Please scan as correspondence with agent in relation to LU/110/20/DOC

Subject: RE: Littlehampton, Cornfield Close E0/SS4/19/DOC

Subject: RE: Littlehampton, Cornfield Close LU/354/19/DOC

PARKING PLAN

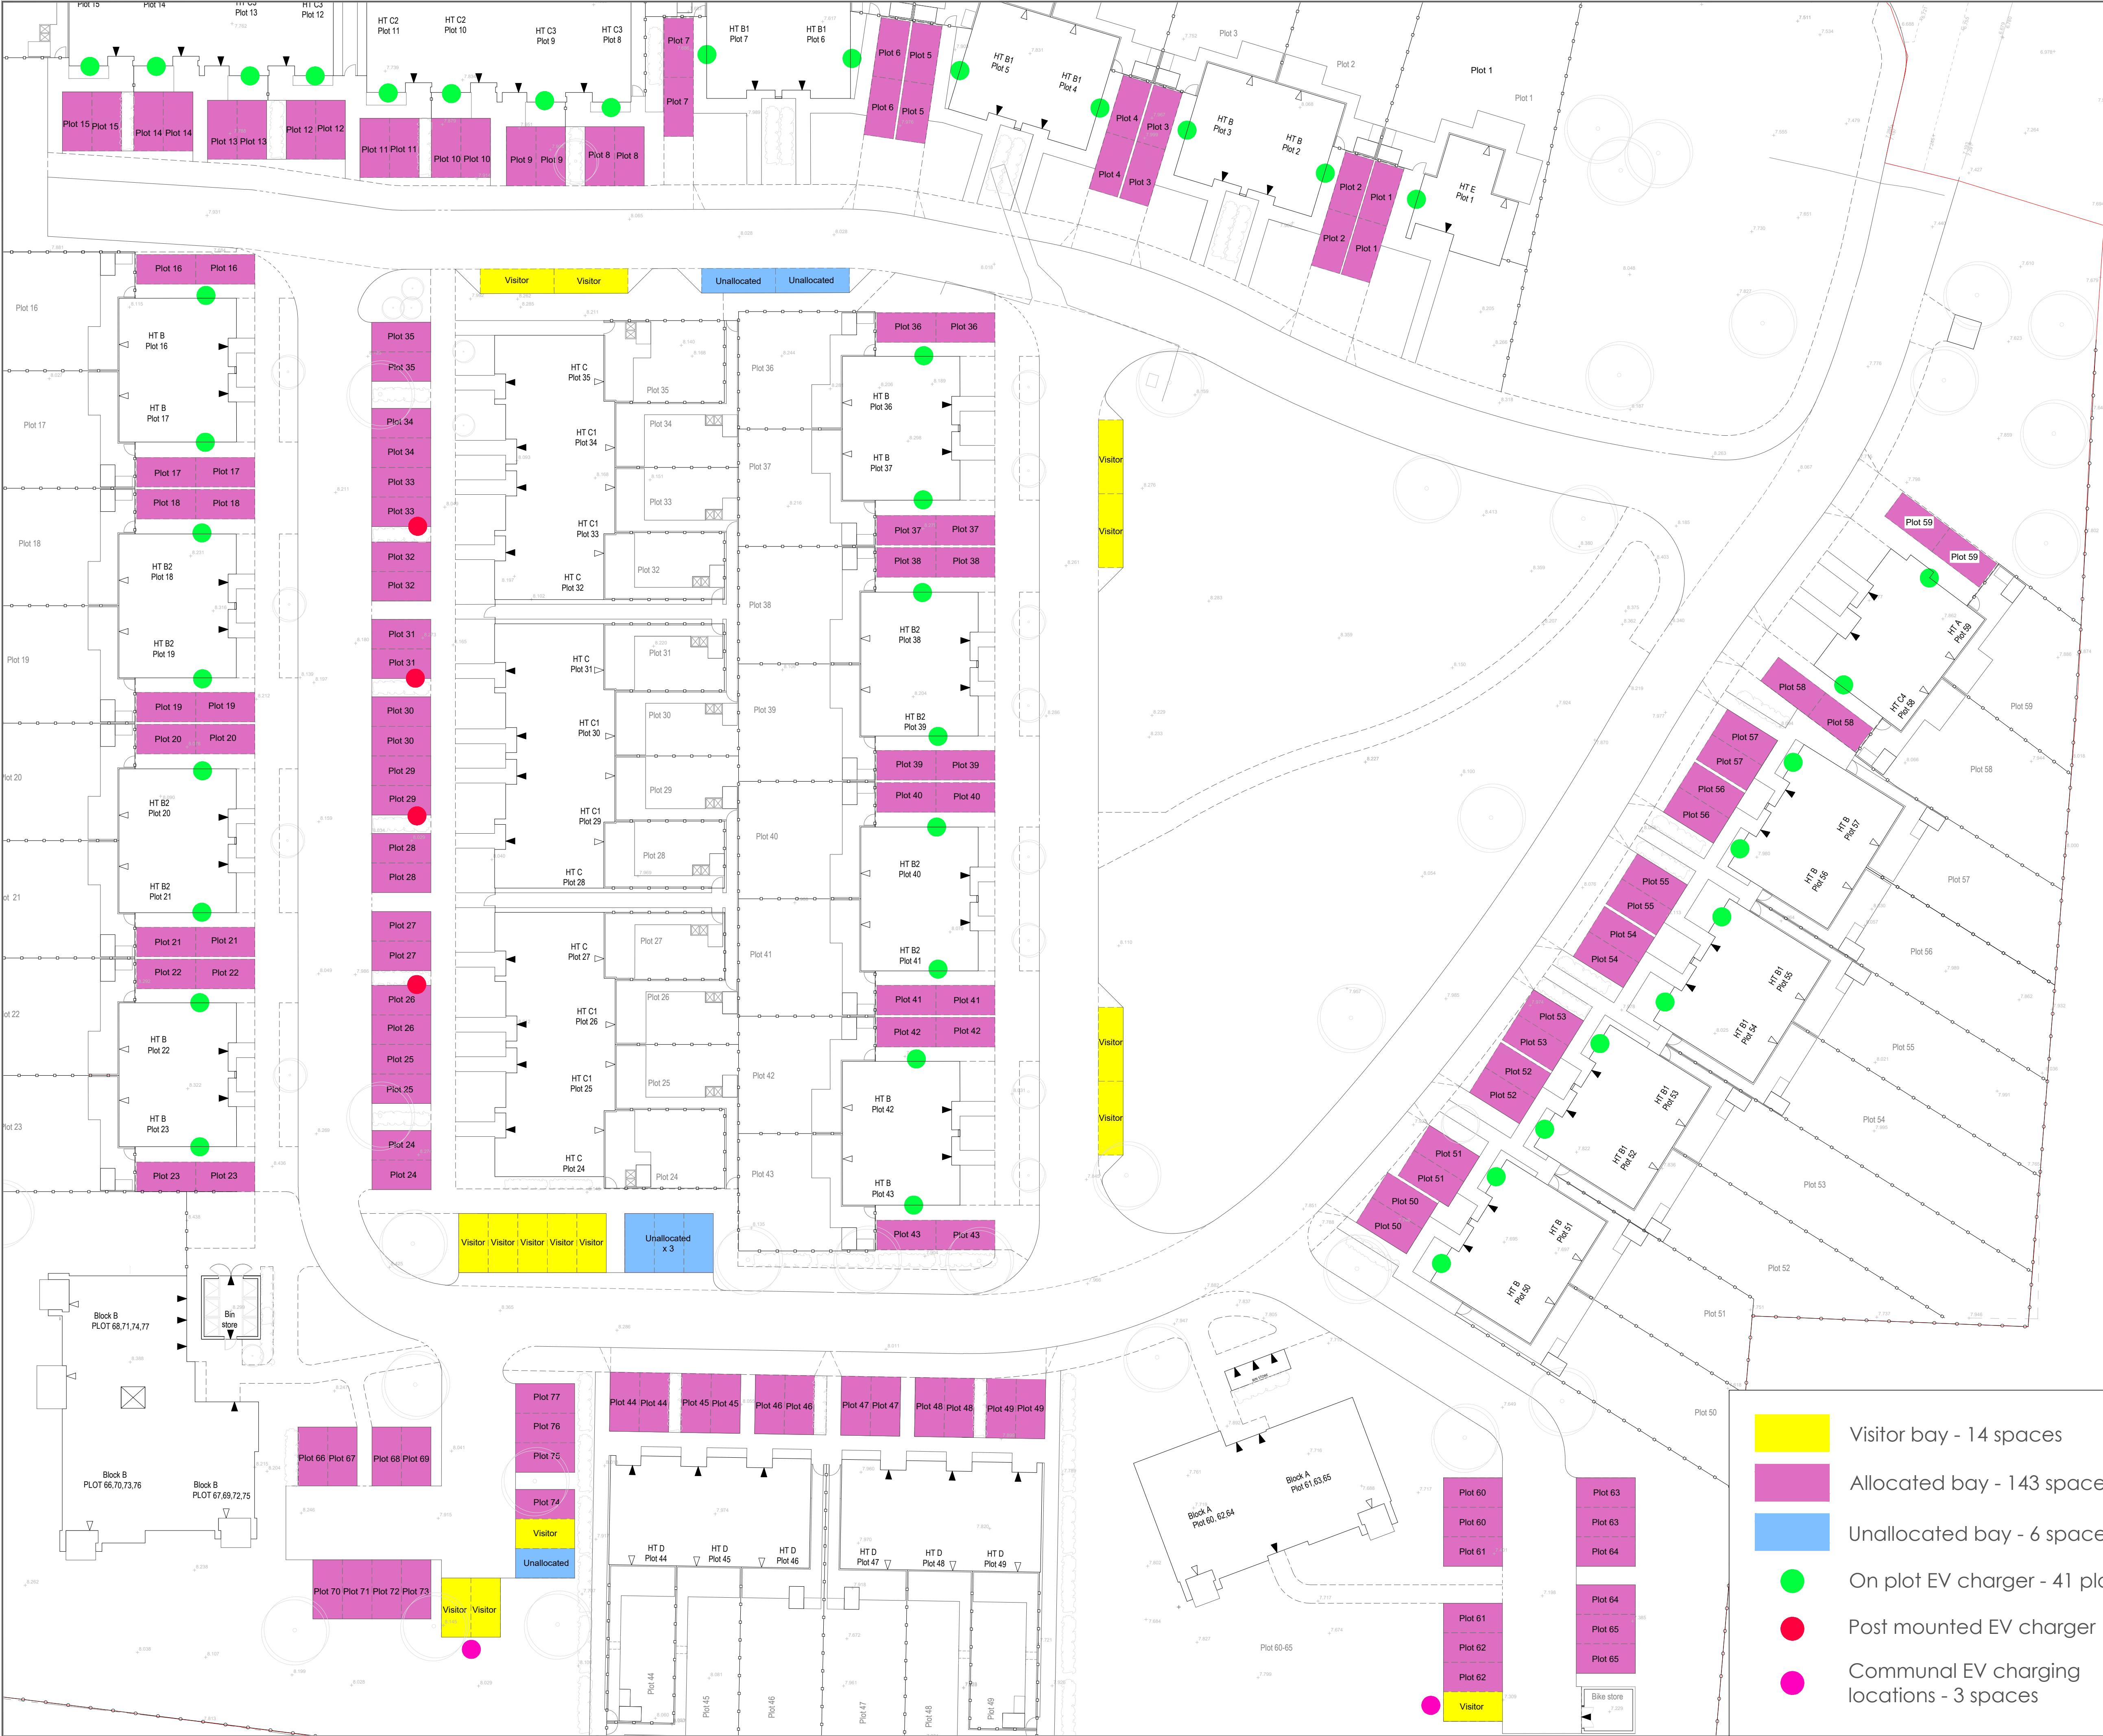
For units that don't have their own driveways and only have allocated parking spaces we would be looking for charging points totalling 20% of the total number of units.

I have now had further discussions with Kate and my Team Leader. Any revised application should detail why the cabling cannot be installed beneath the footpath.

Whilst the reason for the original condition refers to the EV infrastructure study, upon which the recently adopted SPD was based and this states one charge point per house with a garage or driveway, the most up to date policy guidance would be the document used for assessment of any re-submitted DOC and this requires the lower provision of one charge point per house with a driveway and garage.

To clarify my understanding of the EV Charging points the 18 flats within the site within the site require 20% of the total number of units which equates to 4 spaces. You are proposing 3 and we would expect to see a further point to accord with our adopted standards.

Turning to the 59 houses – you were originally proposing 25 points which included plots 1-7, 16-23, 36-43 and 58 and 59 and you have agreed to increase provision to include plots 8-15 and 50-57. Therefore the Plots at issue are 24-35 and 44-49.

As discussed below unless adequate justification can be provided as to why the cabling to these points cannot be provided under the path to avoid health and safety issues then we would be seeking to ensure that each of these units has a vehicle charging point.

I would suggest you re submit with either the charge points provided or a clear reasoned justification set out which can then be considered as part of the Doc.

I have discussed this with the AQ specialist who has advised that every property with a garage or driveway should have their own electric vehicle charging point unless there is a justifiable reason as to why it is not possible. In addition, I do not understand how the installation of cabling which transects a footpath has prohibitive health and safety implications, other than potential excavations for accessing the cable (which can be suitably managed as and when required) but perhaps I have missed the point on this aspect.
